Rezoning Transportation Analysis
Petition Number: Insert Zoning Petition #2020-191
General Location Identifier: Tax ID 08117646

Revision Log:	Date	Description
	01-21-21	First Review (WB)

**RZ.01**

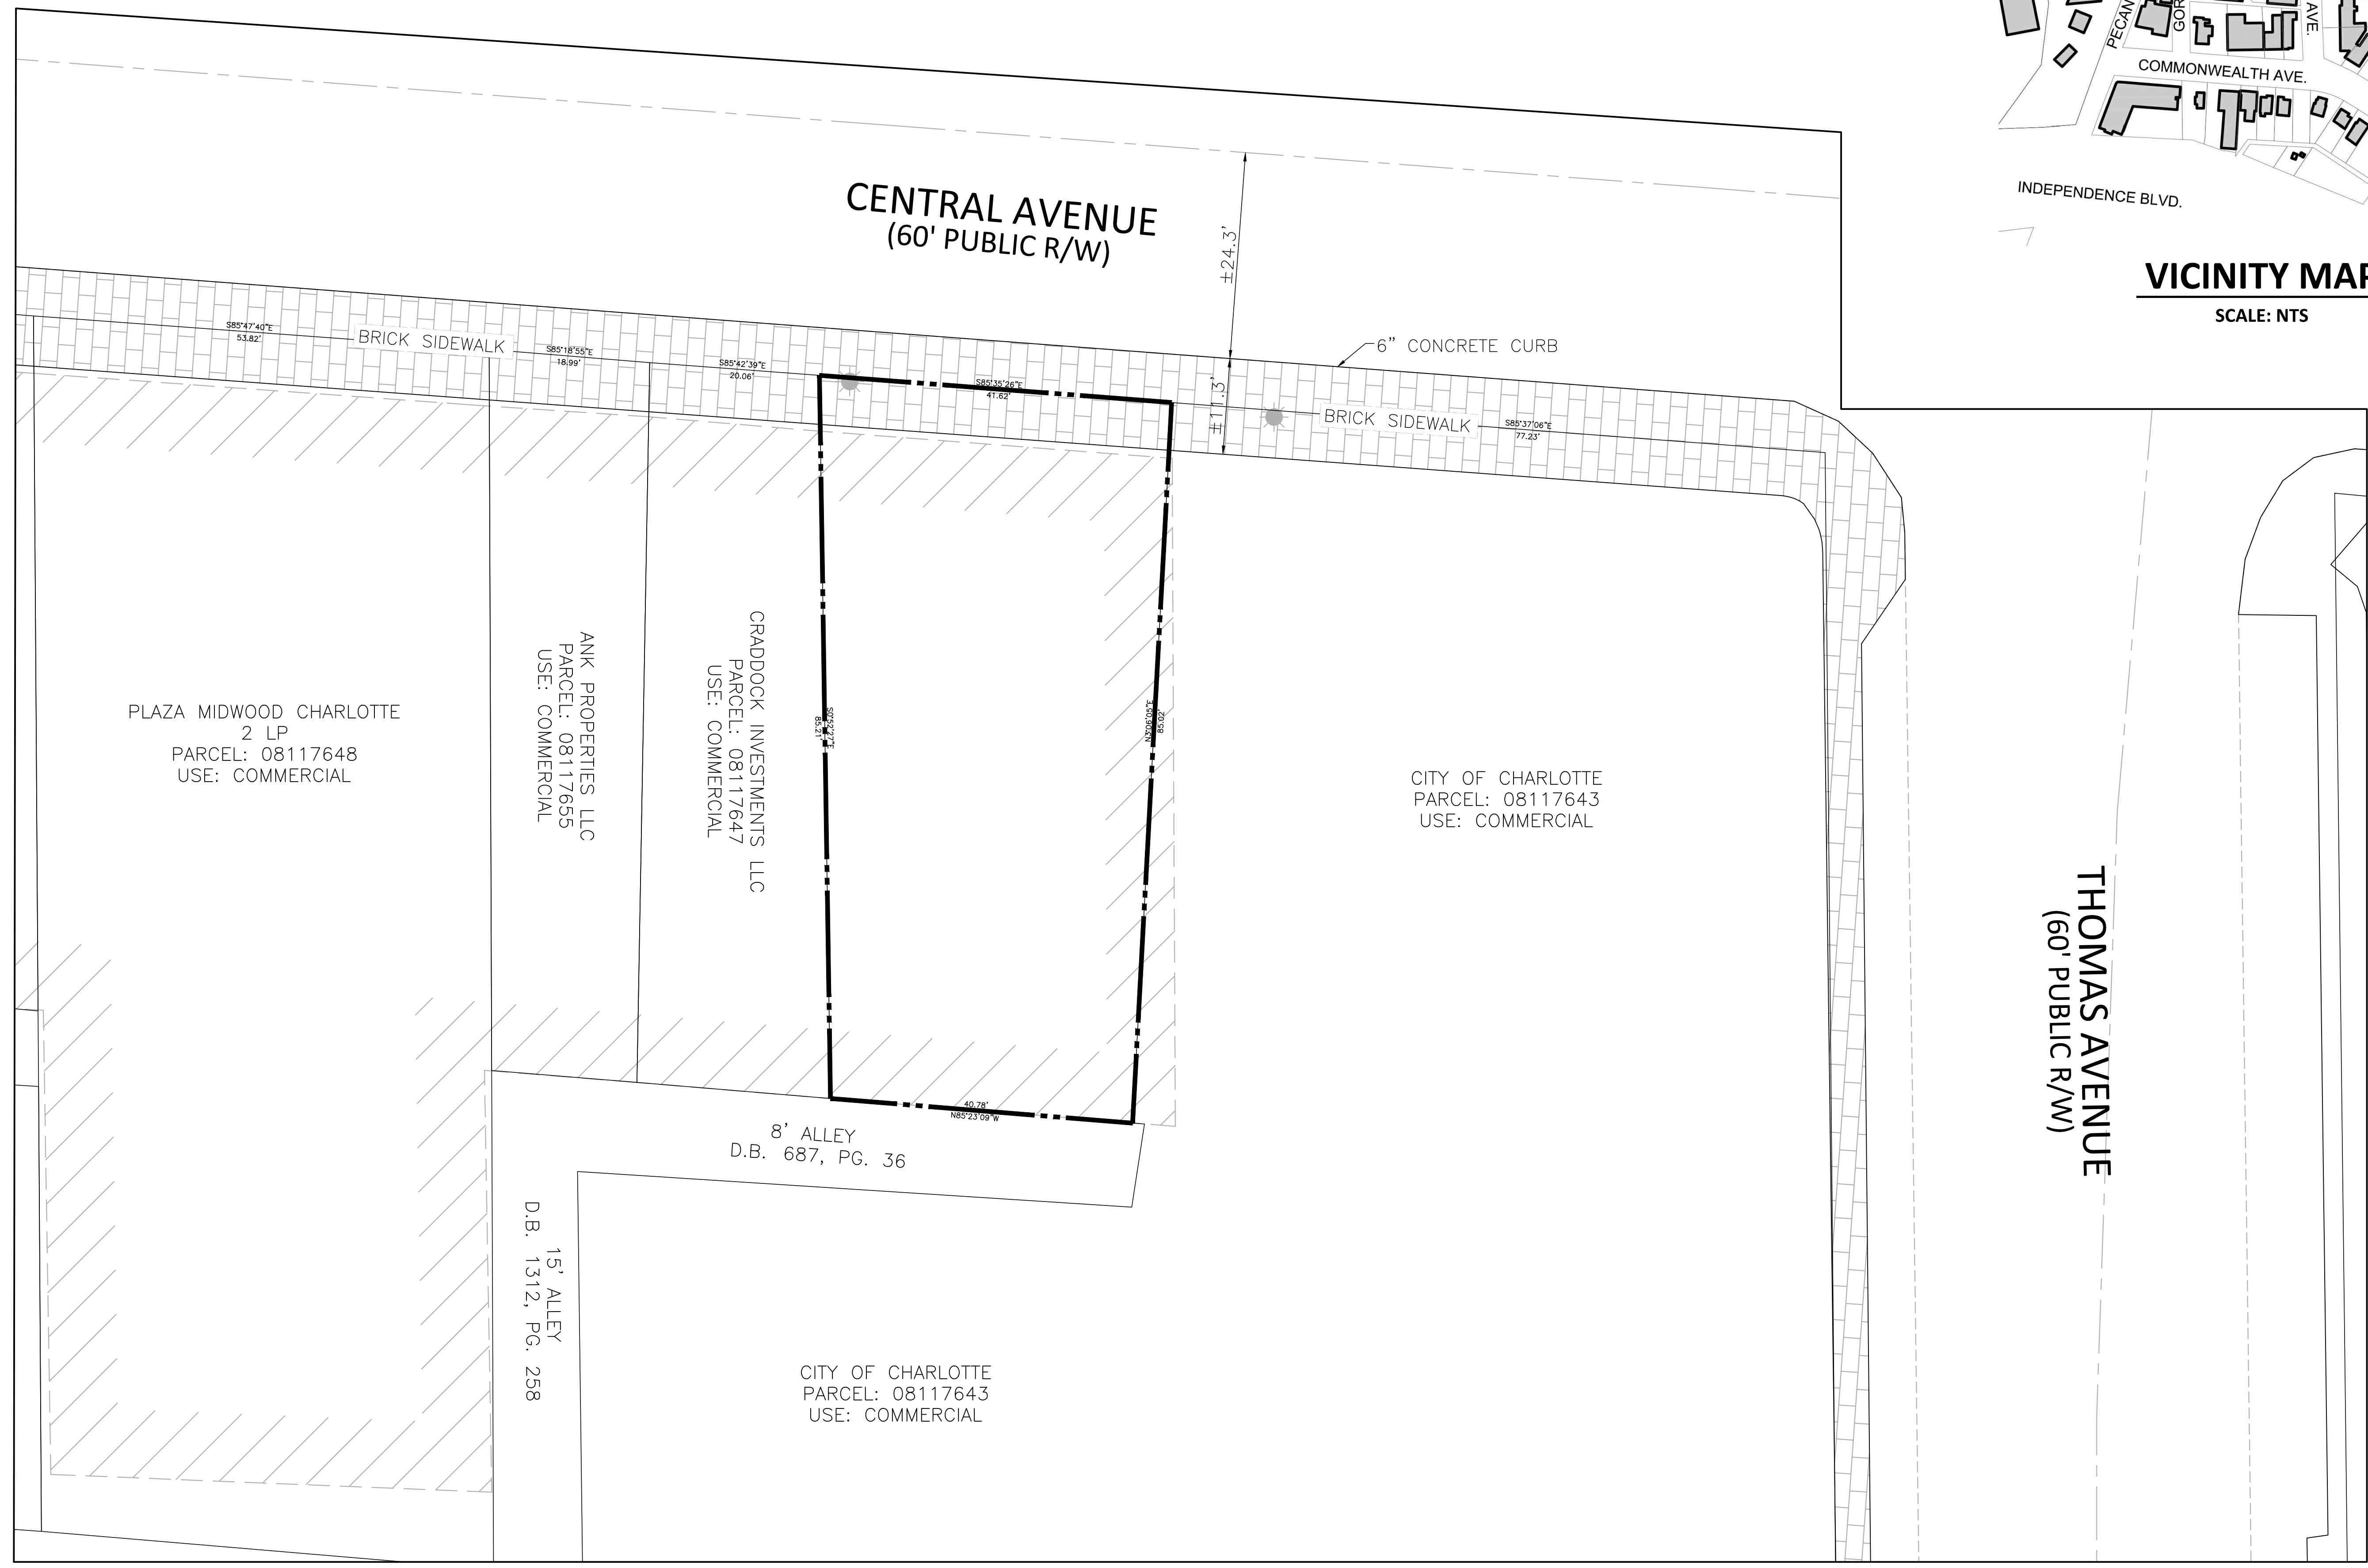
Label and dimension the curb and gutter from the centerline for each road on the site plan.

3. Revise site plan and conditional note(s) to commit to dedicate 40' right-of-way from the road centerline. The site plan shall label and dimension the right-of-way from the road centerline.

4. A site plan note(s) specifying dedication and fee simple conveyance of all rights-of-way to the City before the site's first building certificate of occupancy is issued is needed. CDOT requests rights-of-way set at 2' behind back of sidewalk where feasible.
